From: Anita Gardner
Sent: 03 July 2012 08:53
To: Planning.Responses
Subject: FW: R/99/12 Amendments to existing dwelling and new boundary walling - 1 Botany Close, Rustington

Bruce,
Please can you advise if the attached structural calculations are satisfactory for the proposed boundary walling which abuts a greensward used by the public. If you need to look at the plans you can borrow the file if necessary, reference R/99/12.
At this stage I can't get the attached information scanned since it isn't printable from our system so I have requested a hard copy.
Thanks
Anita

Further to our recent correspondence please see attached structural calculations for the new boundary wall to the east and southern boundaries.

STRIP FOOTING ANALYSIS AND DESIGN (BS8110-1:1997)

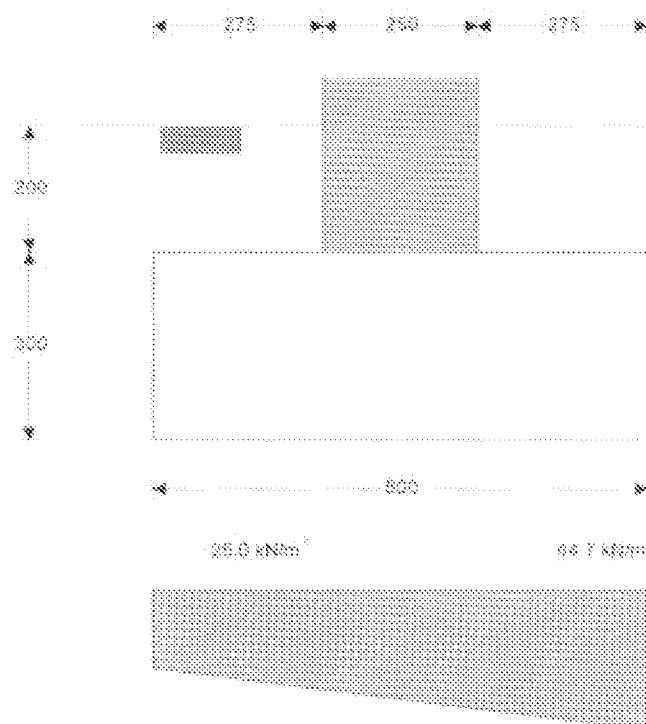
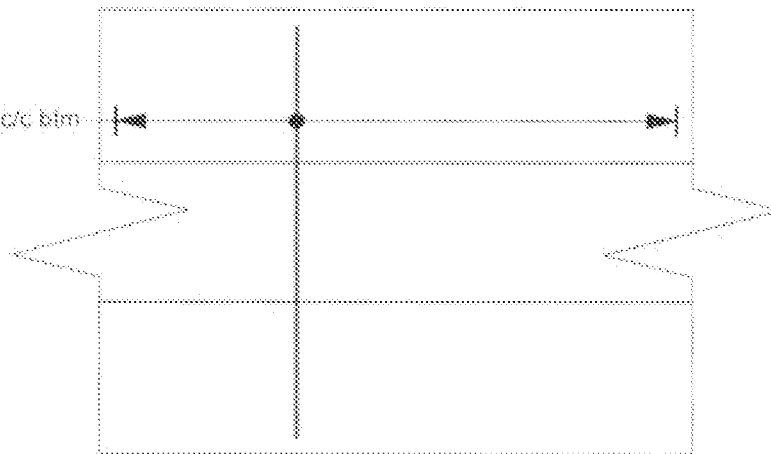
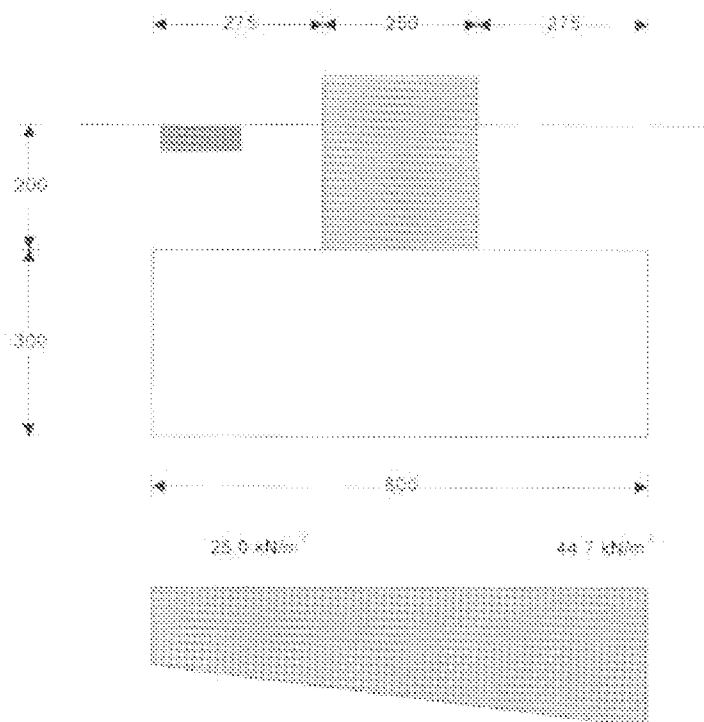
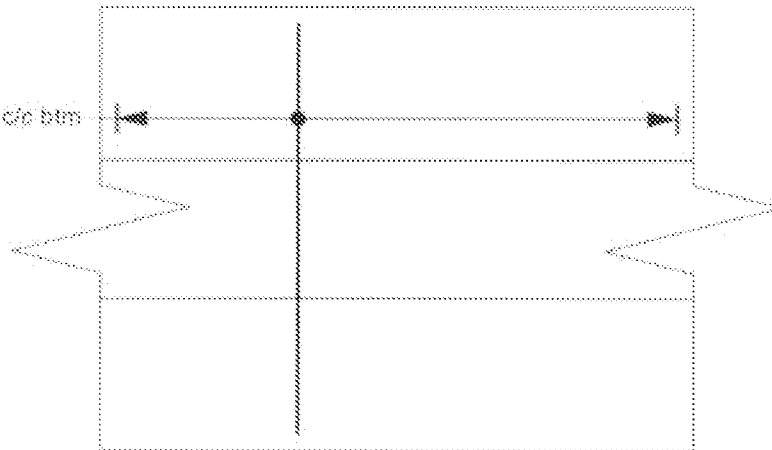
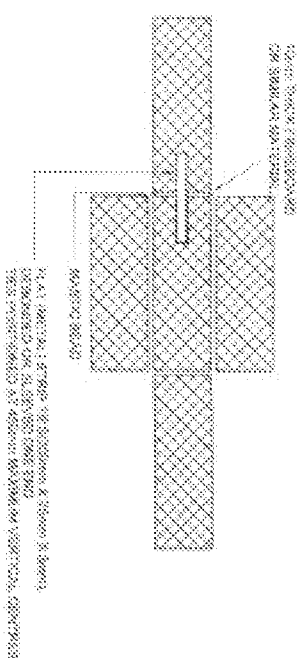
My apologies for not responding sooner. With regards to the proposed wall design calculation, although the allowable soil bearing capacity for the foundation design has been over assumed, the results are within normal tolerances and therefore considered acceptable.
